## Memorandum

To:	Tim McHarg	Date:	May 4, 2022
From:	April Ng		
Project:	Buttenwieser/Wiley Residence 6838 96 <sup>th</sup> Ave SE Mercer Island, WA 98040 King County APN 302405-9010	File No:	<b>CAO21-007</b> <b>SHL21-042</b> <b>SEP21-027</b>
Subject:	<b>Land Use Resubmittal</b>

This memorandum responds to comments received from Tim McHarg, Principal Planner at the City of Mercer Island's Community Planning & Development Department dated February 25, 2022 for File numbers: CA021-007/SHL21-042/SEP21-027 – Buttenwieser/Wiley Residence.

TOPOGRAPHIC & BOUNDARY SURVEY

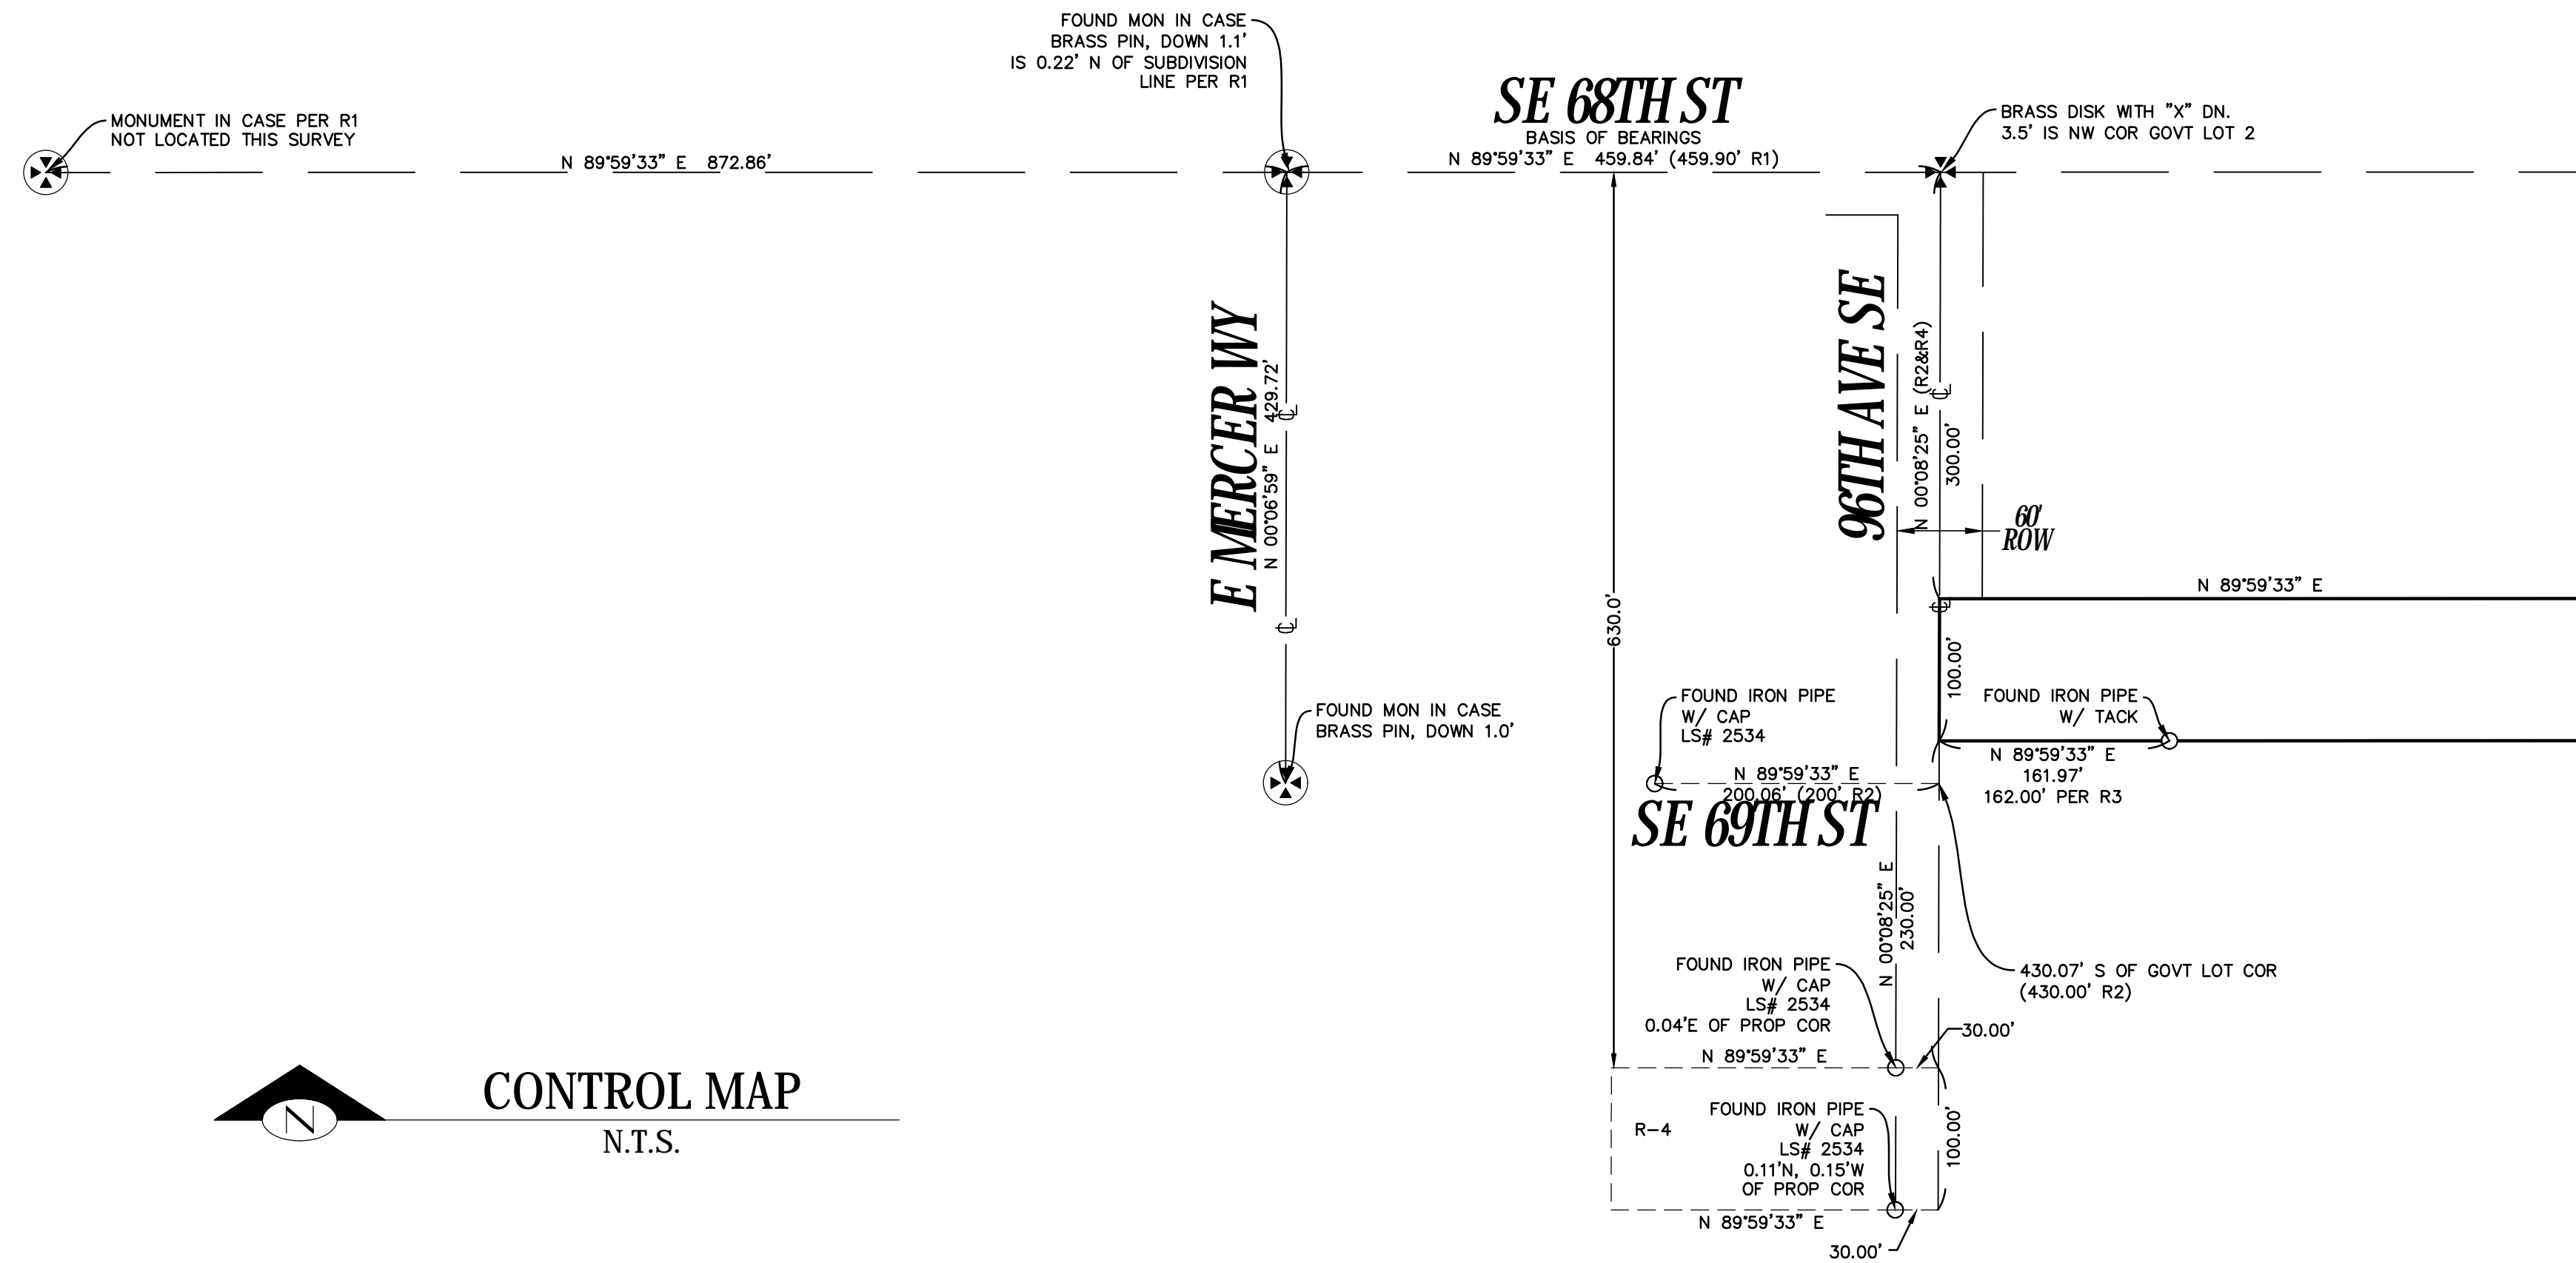
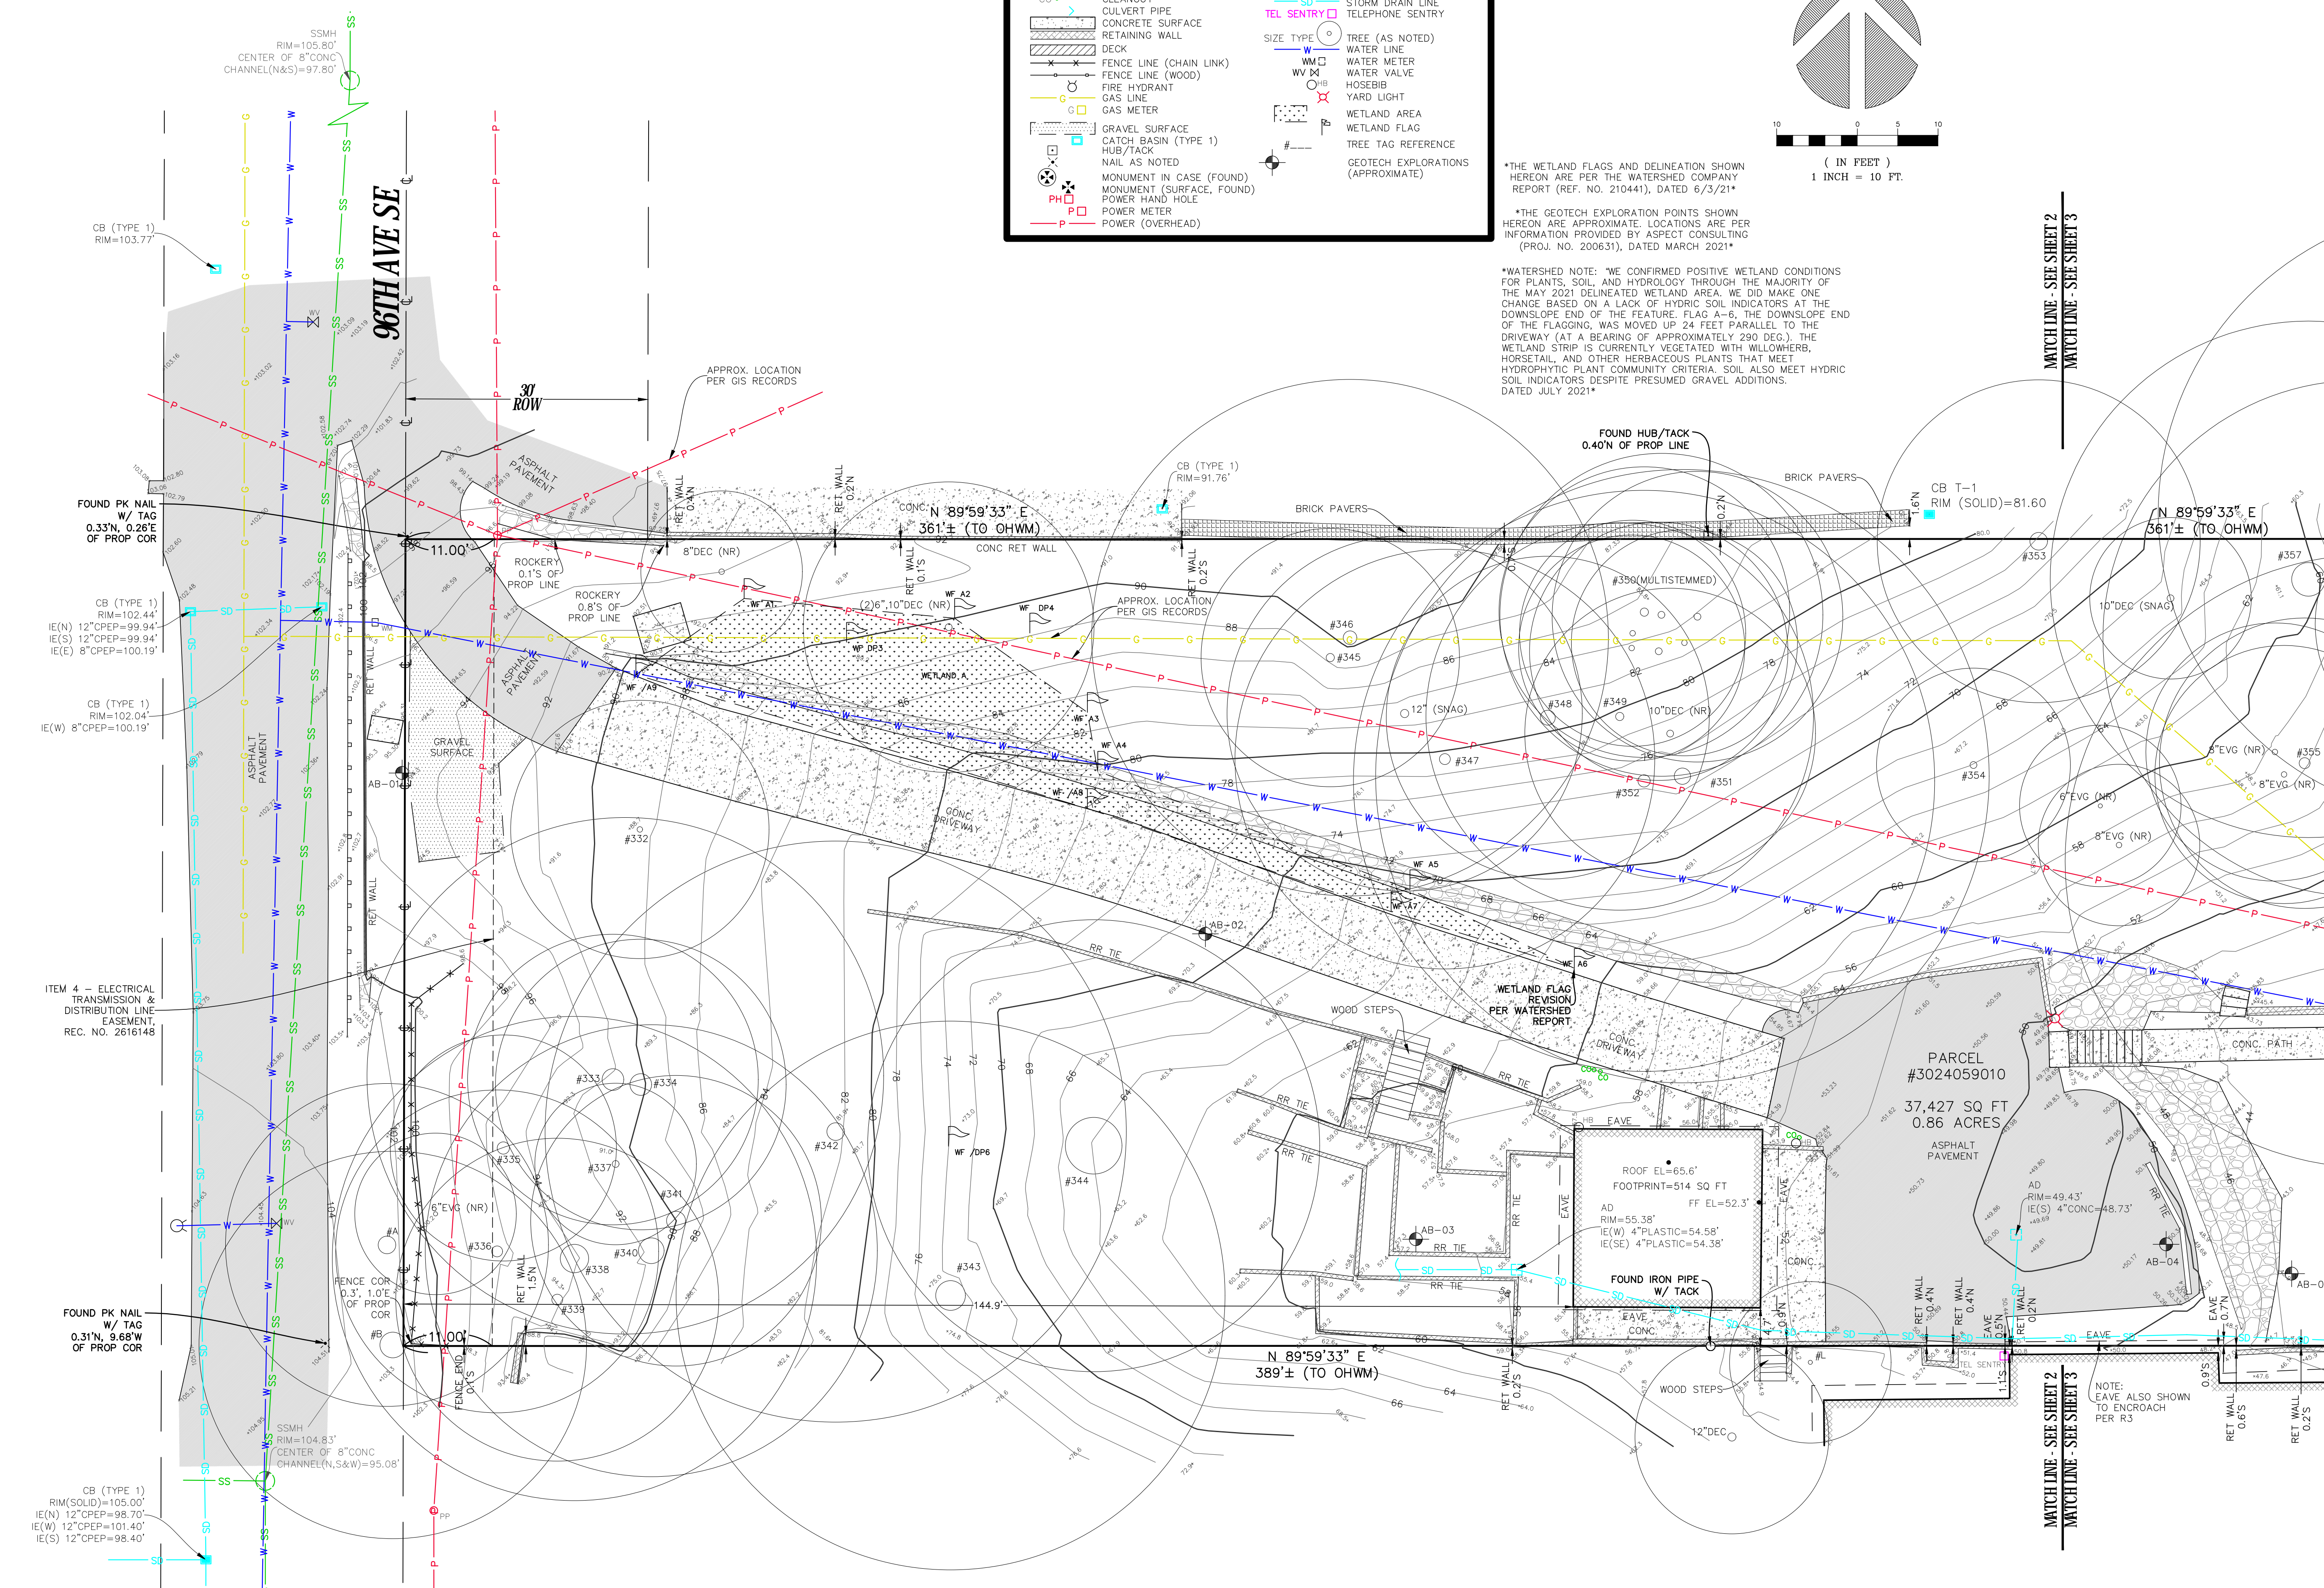
2. Please show the following easement on the survey:	The survey easement is noted as number 5 in Schedule B of the survey. The surveyor was unable to plot this	Survey, Page 1

<p>Grantee: Mercer Island Sewer District.          Purpose: Sewer Line          Recording No.: 5750932</p>	<p>easement since it is written as blanket in nature. The team has attempted several times to scope the existing sewer but due to existing bends in the line, the team was unable to complete the sewer scope. The team plans on completing the sewer scope once access is achieved, which will require removal and abatement of an existing asbestos cement pipe.</p>	
<p>3. Plan Set:          a. Sheet G101: Please clarify the encroachment into the 10' variable side yard setback highlighted in red below:</p>	<p>The diagonal hatch indicates the existing building footprint as noted in the Site Plan Legend. The proposed building does not encroach the 10' variable side yard setback.</p>	<p>G101</p>
<p>b. Please confirm the height of the detached garage is below 15' from existing or finished grade, whichever is lower. If the garage is greater than 15' in height, a variable side yard setback will apply.</p>	<p>The garage is less than 15' from existing grade. We will include elevations with our building permit submission.</p>

CODE DIAGRAMS G201

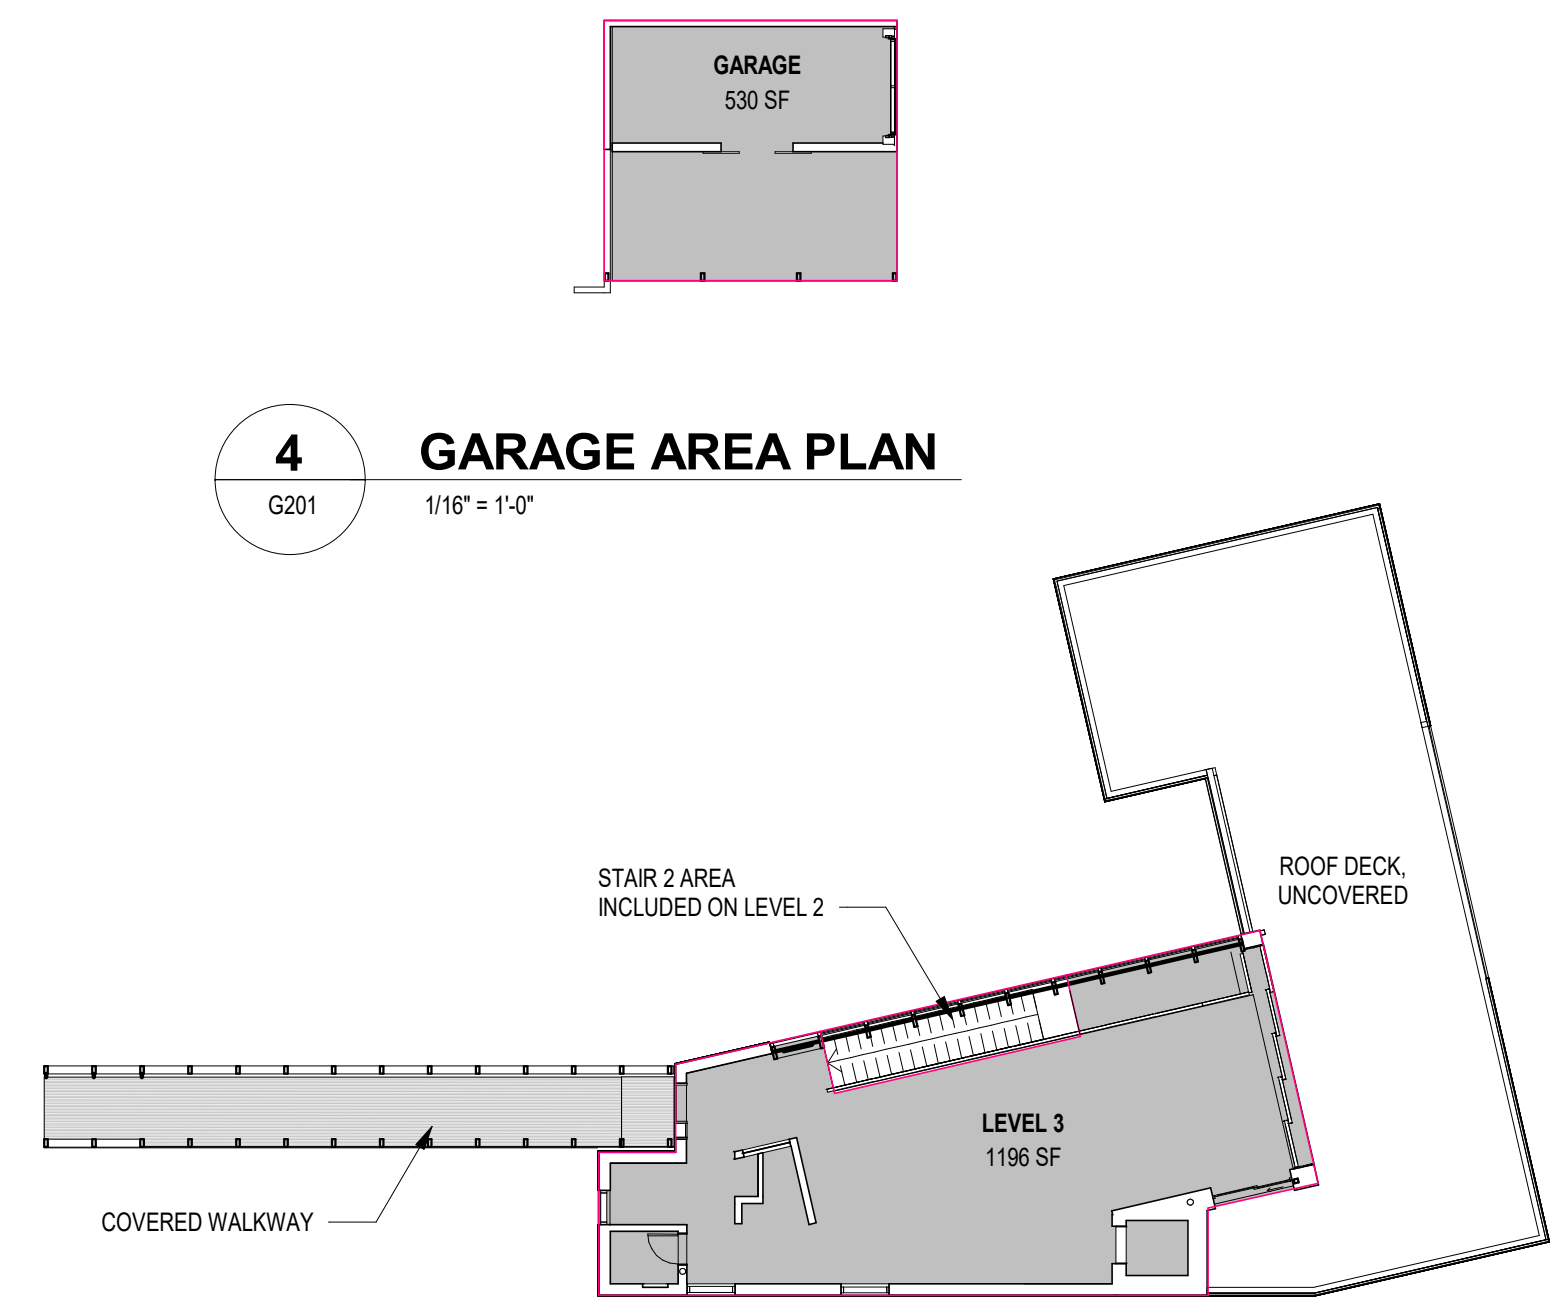
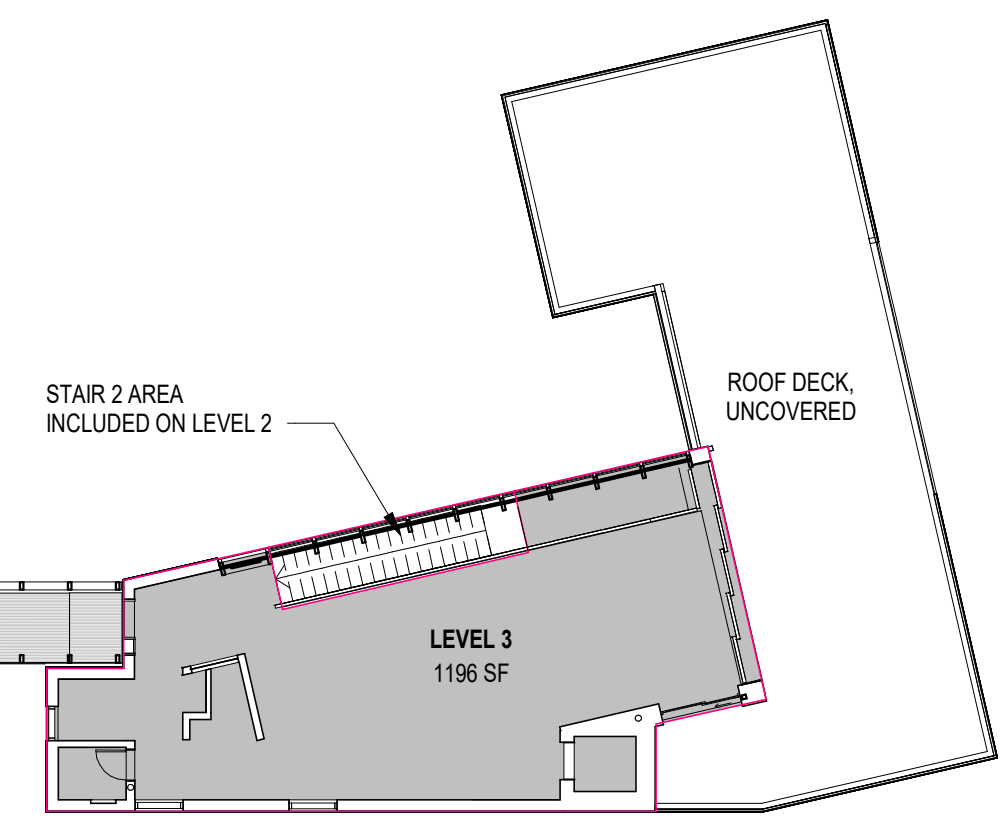
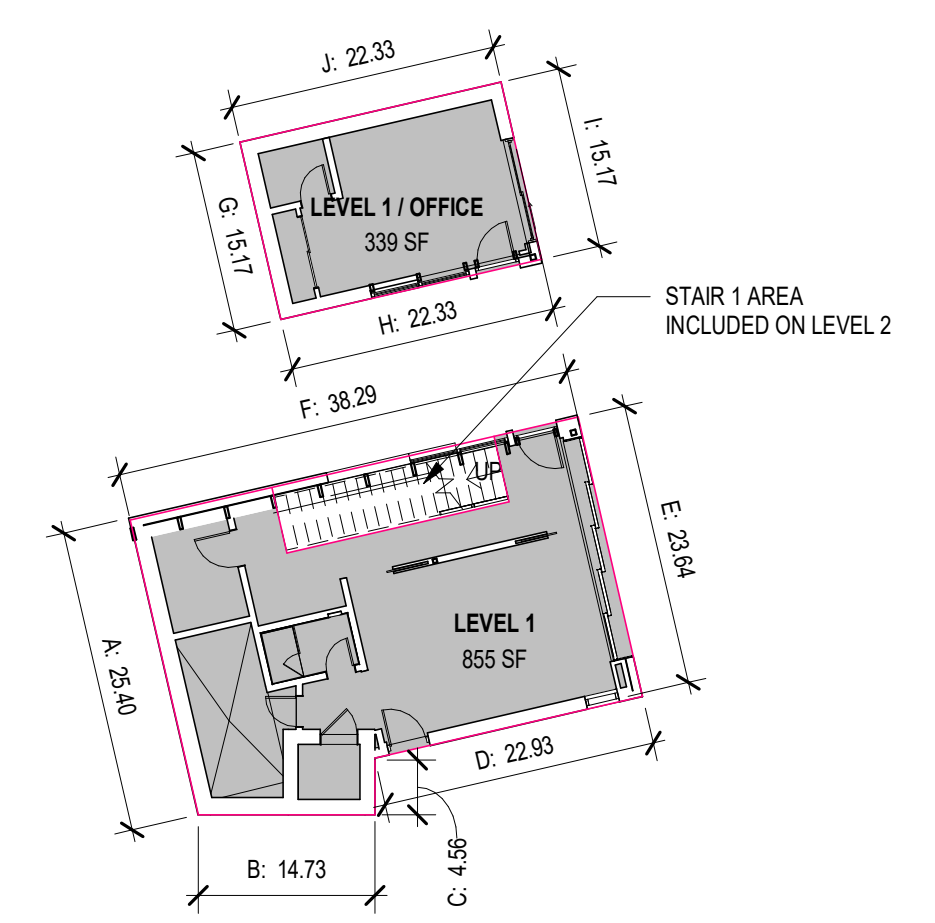
<p>c. At the time of building permit, please provide an ABE calculation for the detached garage.</p>	<p>We will include ABE calculations for the detached garage with our building permit submission. It will be included on G201.</p>	
<p>d. Note that all encroachments into the side yard setbacks must be 30" or less from grade. Eave and other minor building element encroachments greater than 30" from grade are prohibited within side yard setbacks along interior lot lines per MICC 19.02.020(C)(3)(a)(ii)</p>	<p>We don't anticipate eaves or other minor building elements encroaching into the side yard setbacks. We will include building elevations with the building permit submission to help clarify.</p>
